DOC19/544951
SSI 7308

27 June 2019

EIS for St Marys Intermodal (St Mary's Freight Hub) - Request for EPA Comment

I refer to the request from the Department of Planning and Environment (DPE) to the NSW Environment Protection Authority (EPA) dated 28 May 2019 to undertake a review of the Environmental Impact Statement (EIS) for the proposed St Marys Intermodal project SSI 7308.

Source:

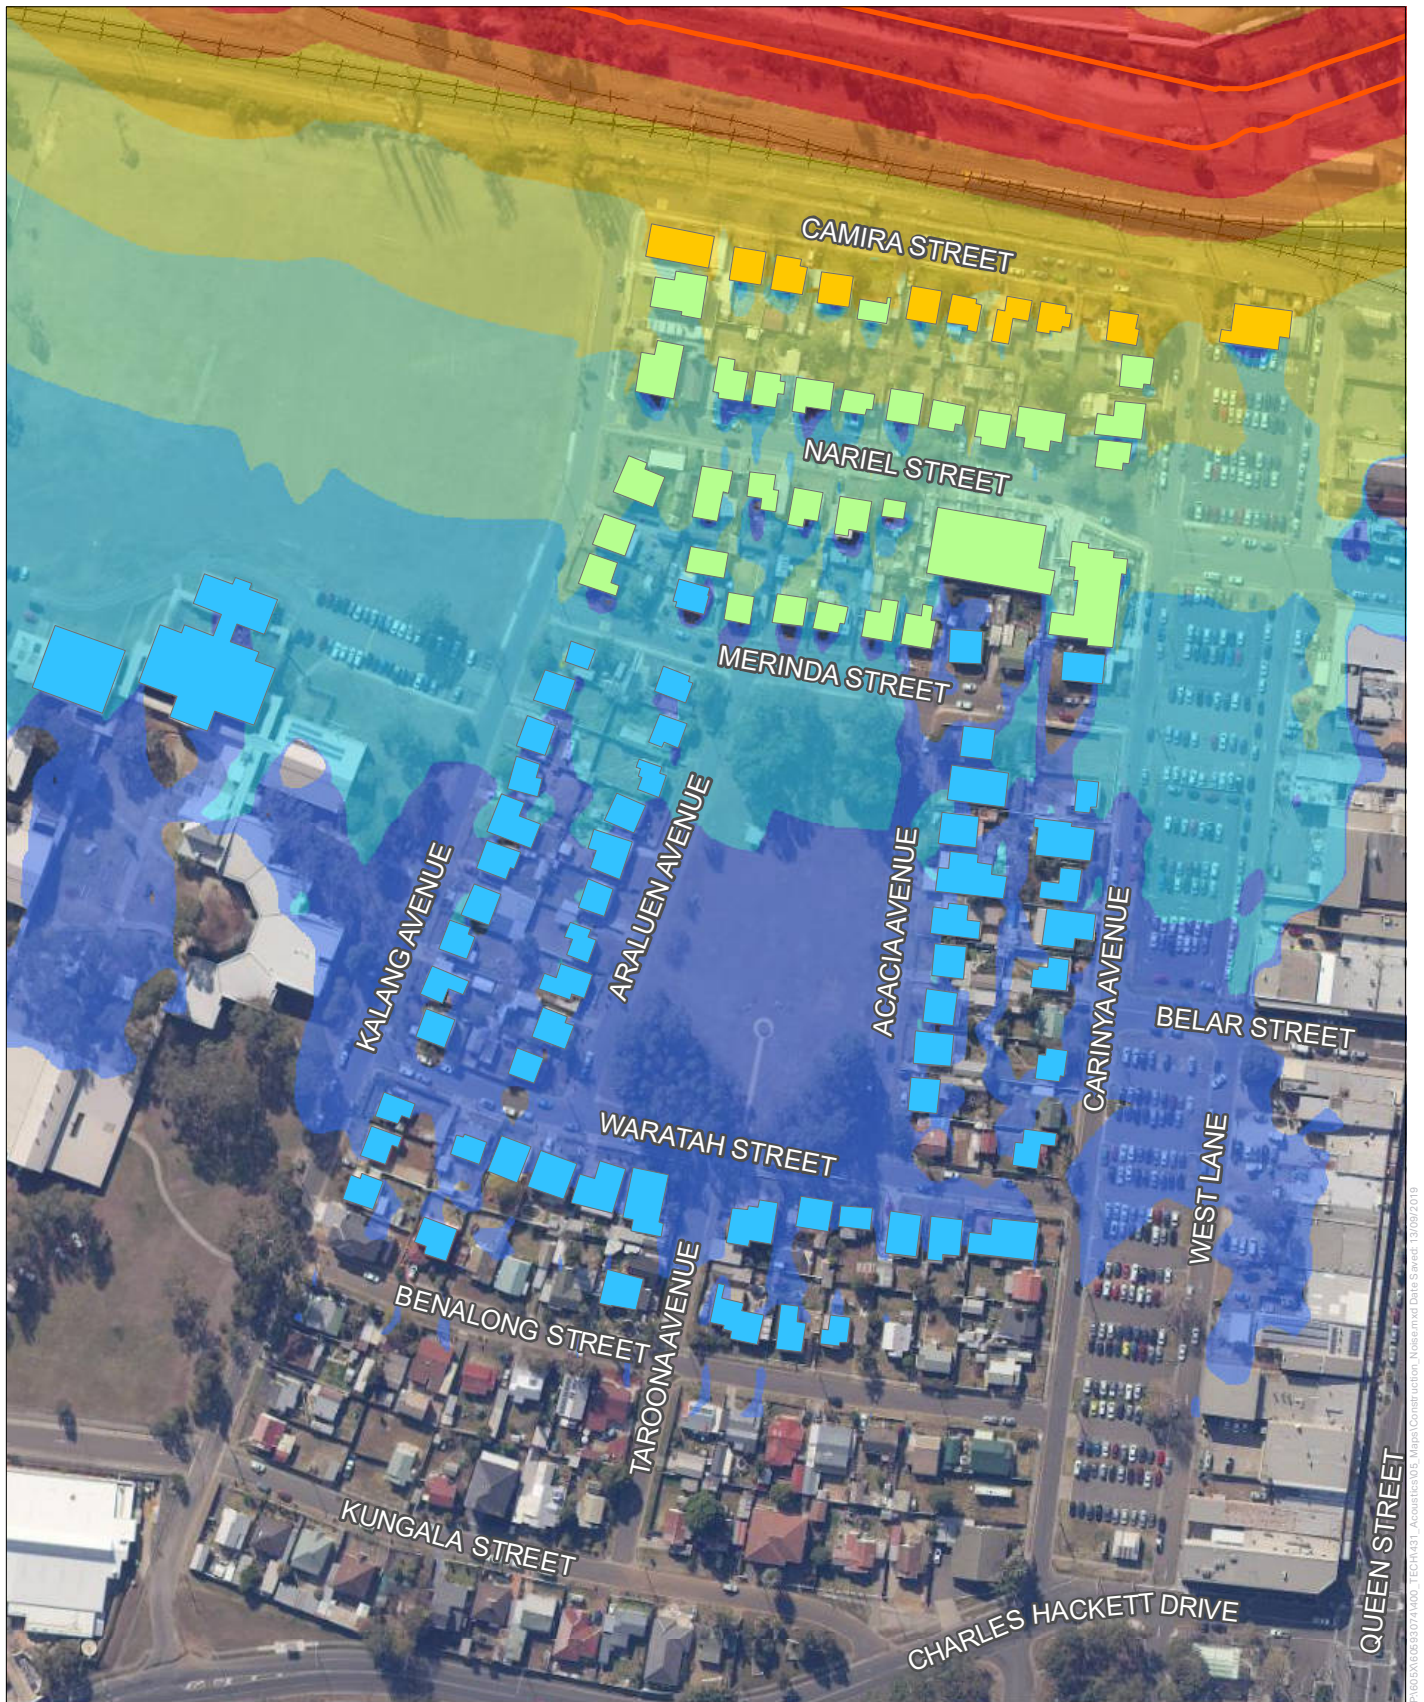
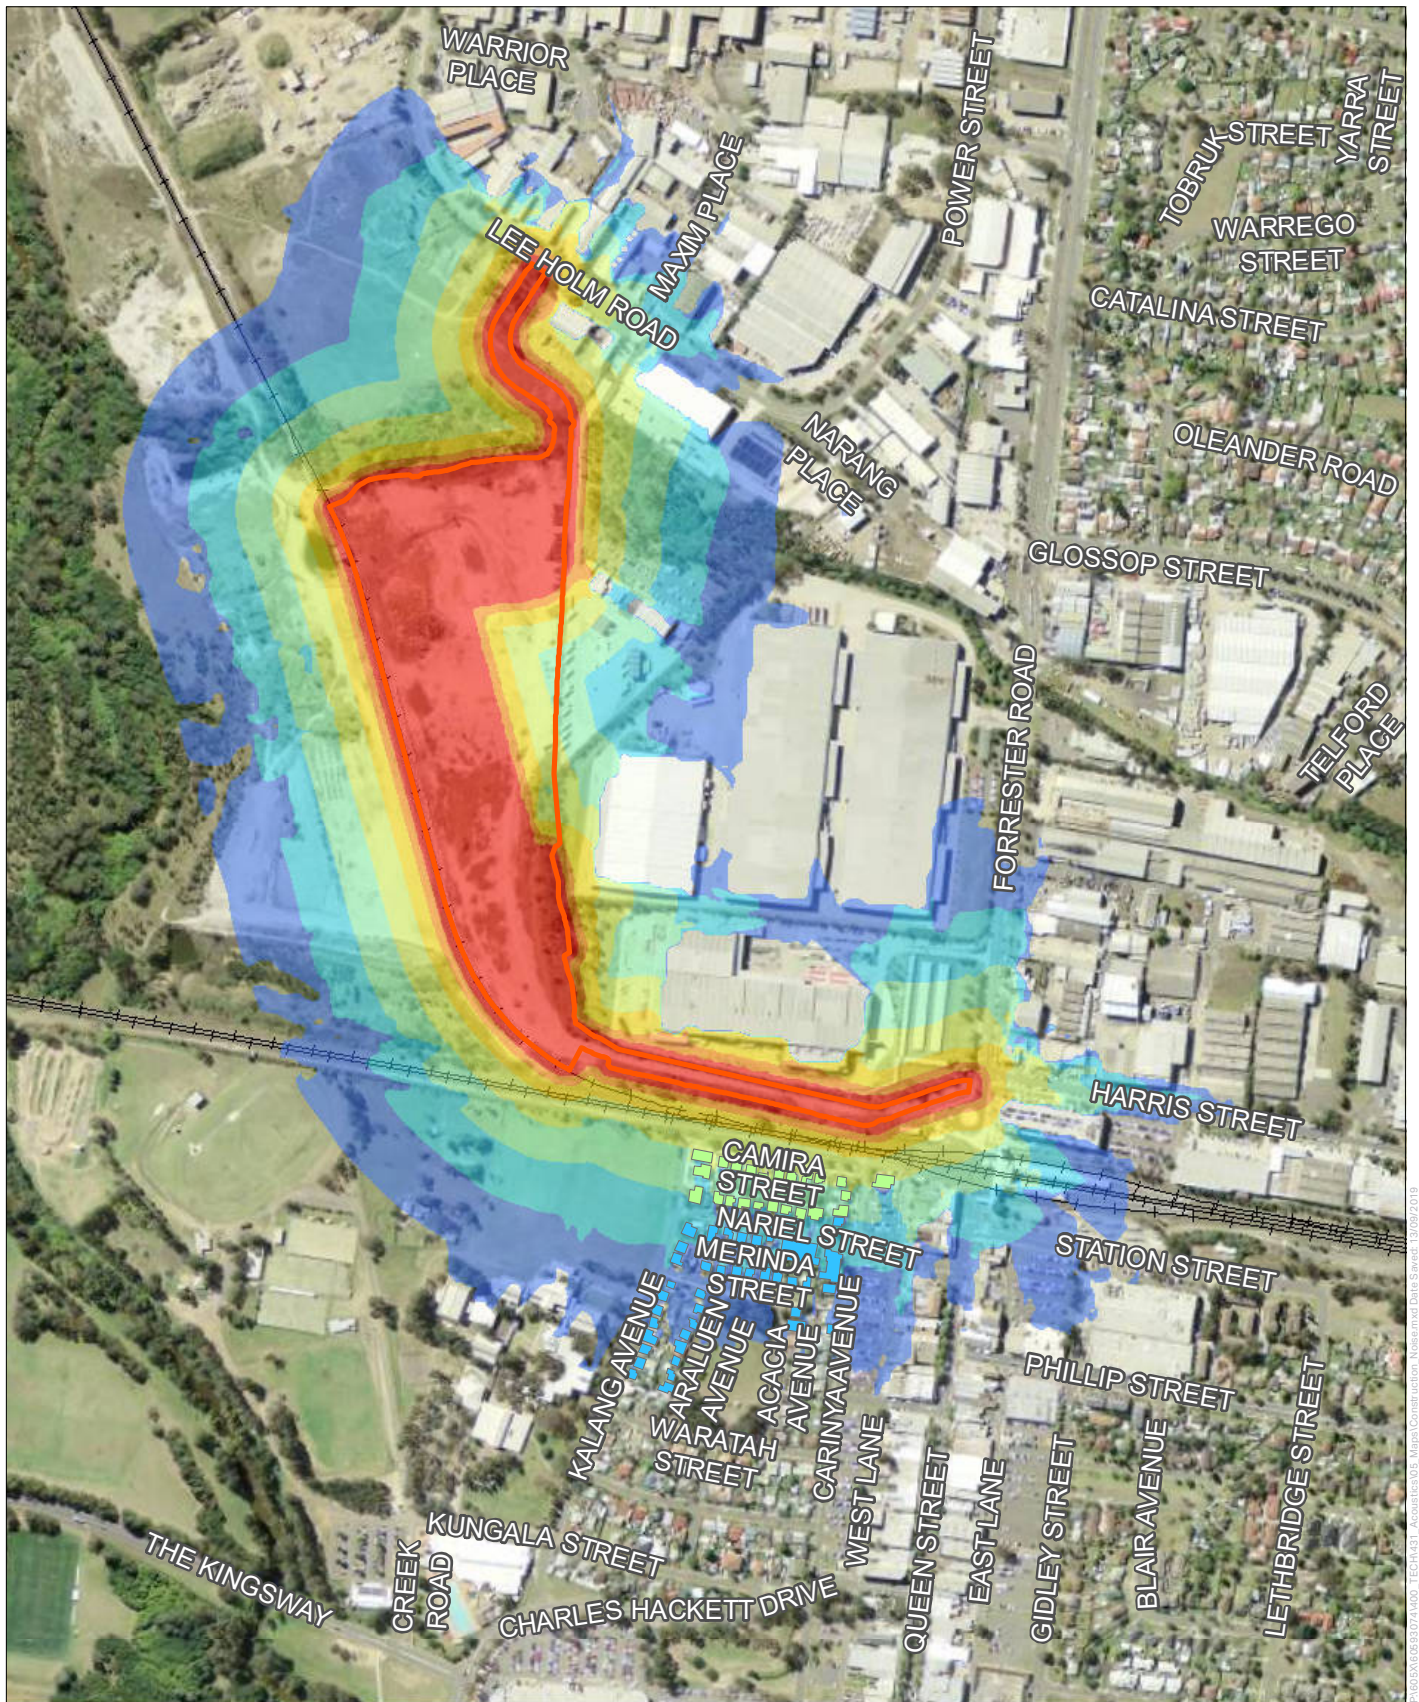
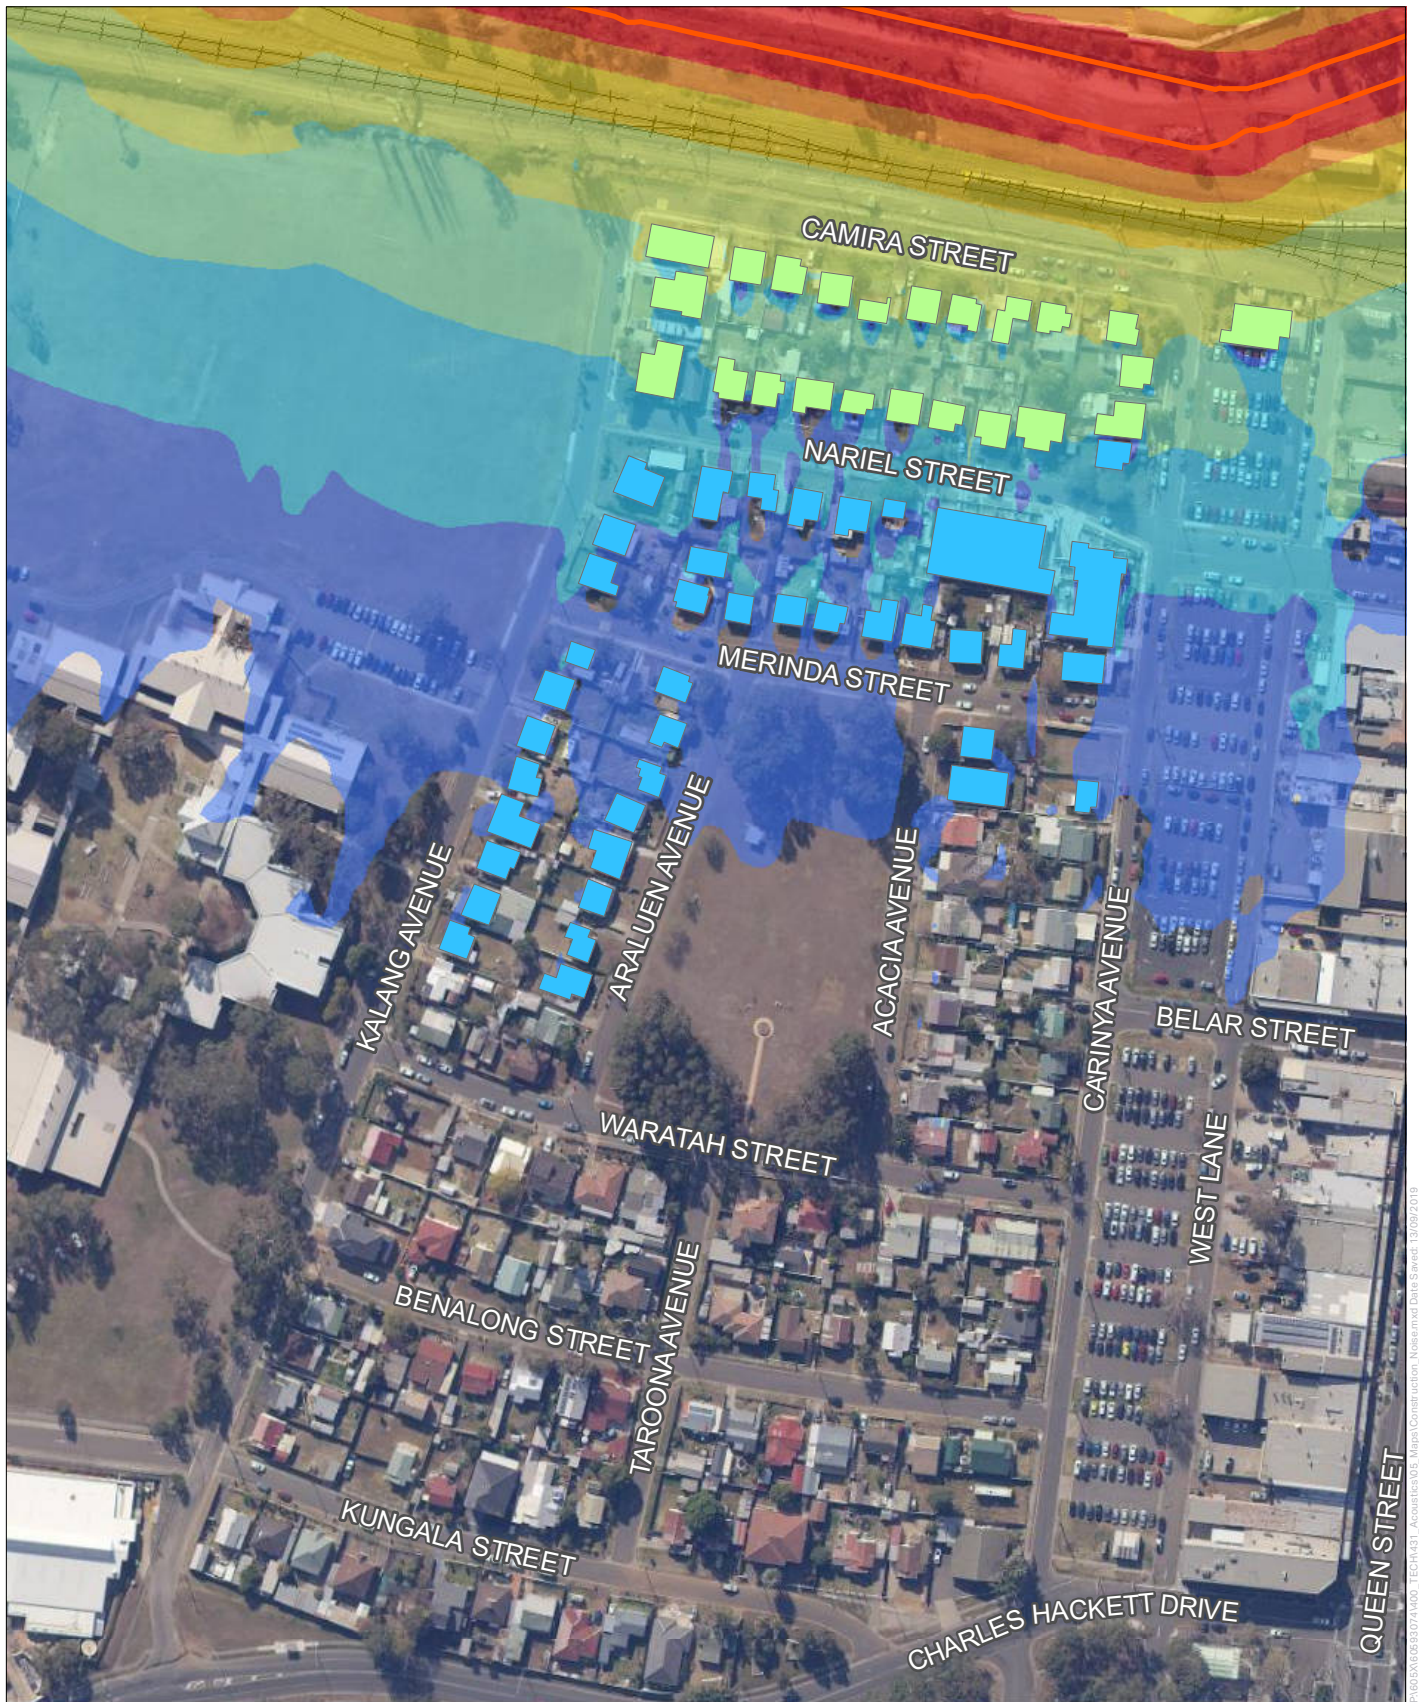
1. Maps in Appendix C of the noise report use highlighted buildings to identify impacted receivers. However, buildings are obscured by the road names. The maps should be updated so that individual buildings can be more easily identified.
2. Section 5.4.1 of the noise report gives a summary of the number affected above the NML, however it does not differentiate between residential and other receiver types. The report should provide a clear indication of the impacts in each NCA and the receiver types for each work package.
3. Construction must to be limited to standard hours:
7am to 6pm Monday to Fridays
8am to 1pm Saturdays
No work Sundays and Public Holidays
4. A construction noise and vibration management plan should be used to manage construction impacts in accordance with the Interim Construction Noise Guideline (DECCW, 2011)
